**RE: Harnett County Land Use Existing Tank Application # 16-5-38229**

The Harnett County Department of Public Health, Environmental Health Division on, March 23, 2016 evaluated the above referenced property at the site designated on the plat/site plan that accompanied your existing tank application. According to your application requesting, a 36 x 50 garage addition, the evaluation was done in accordance with the laws and rules governing wastewater systems in North Carolina General Statute 18A.1950 including related statutes and Title 15A, Subchapter 18A, of the North Carolina Administrative Code, Rule.1950 and related rules.

Based on the criteria set out in Title 15A, Subchapter 18A, of the North Carolina Administrative Code, Rules .1950, the evaluation indicated that the site is **UNSUITABLE** for the addition requested. Therefore, your request for an existing tank is **DENIED**. The site is denied based on the following:

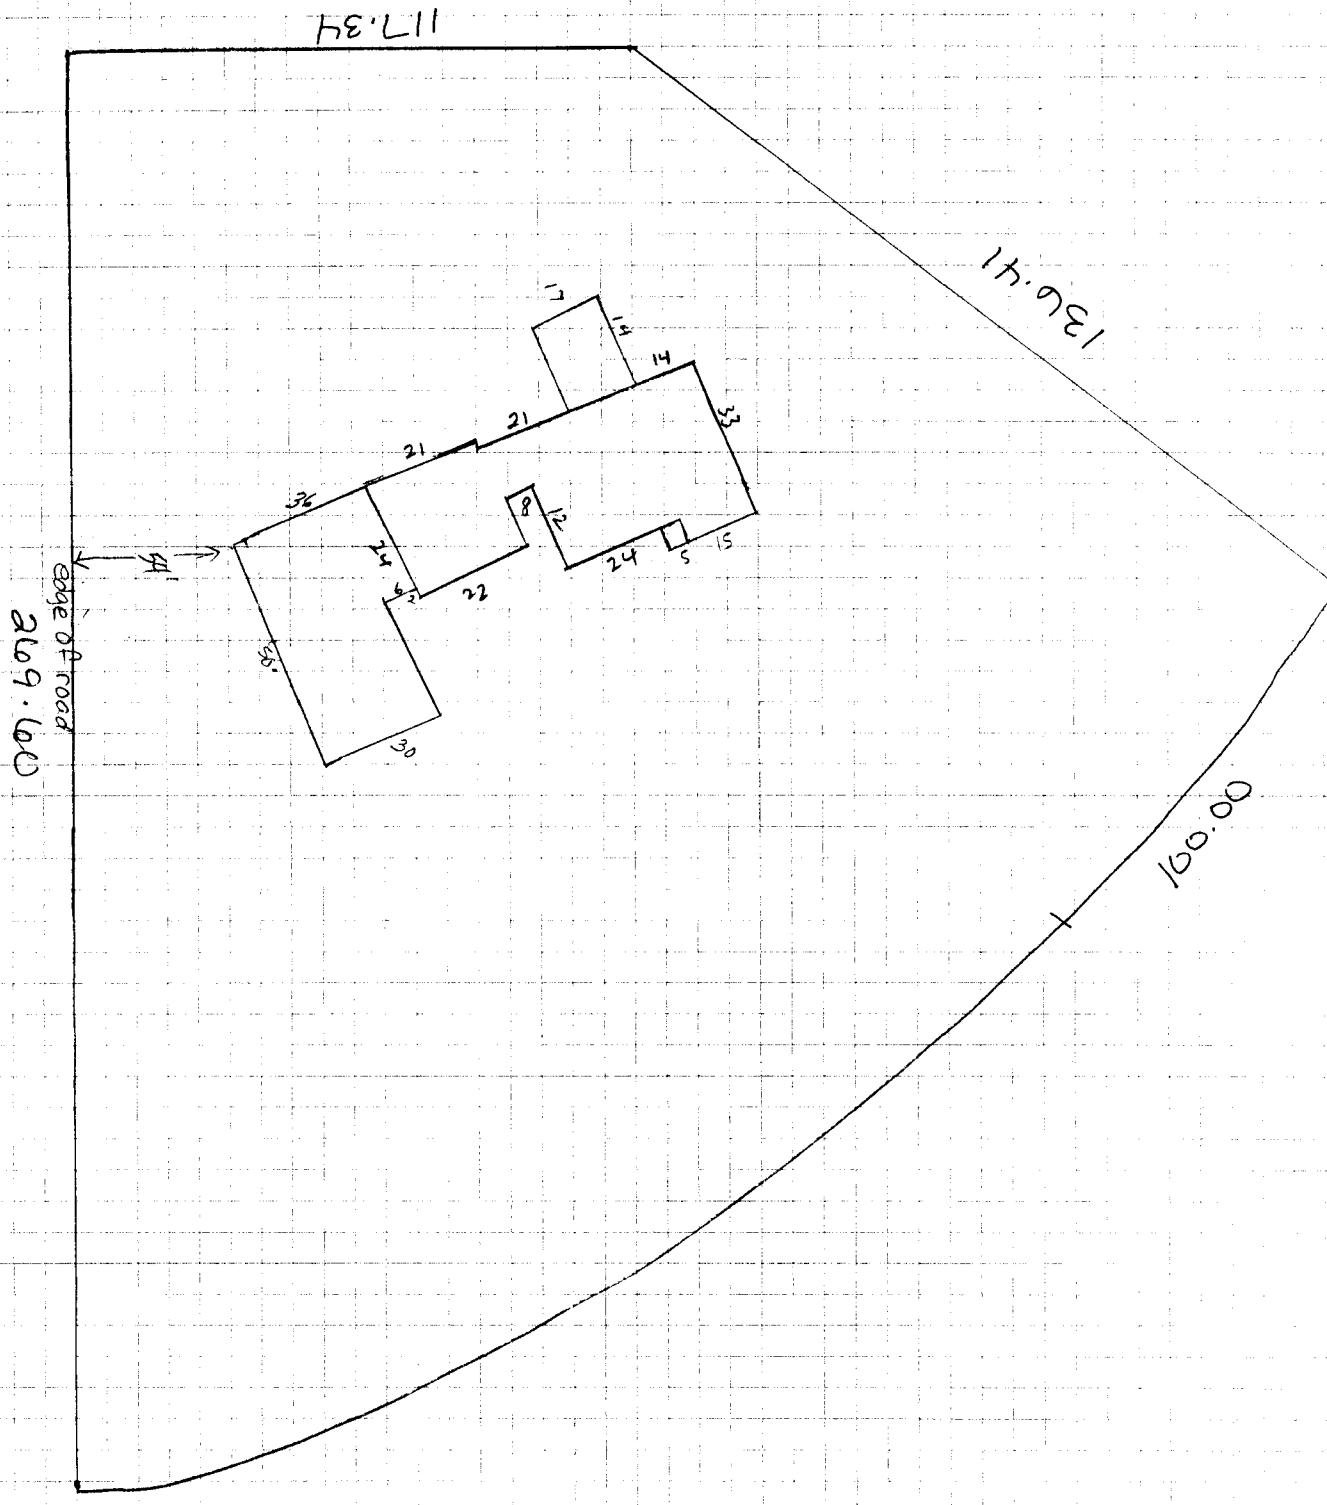
- 15A NCAC 18A.1950a {16} - Any swimming pool must be 15' from any part of septic system.**
- 15A NCAC 18.1945{b} - Each lot shall have original septic system plus repair area.**
- 15A NCAC 18A.1950 {10} - Any building to be 5' from septic tank and/or from drain line.**
- 15A NCAC 18A.1950{c} - Nitrification fields and repair areas shall not be located under paved areas or areas subject to vehicular traffic.**
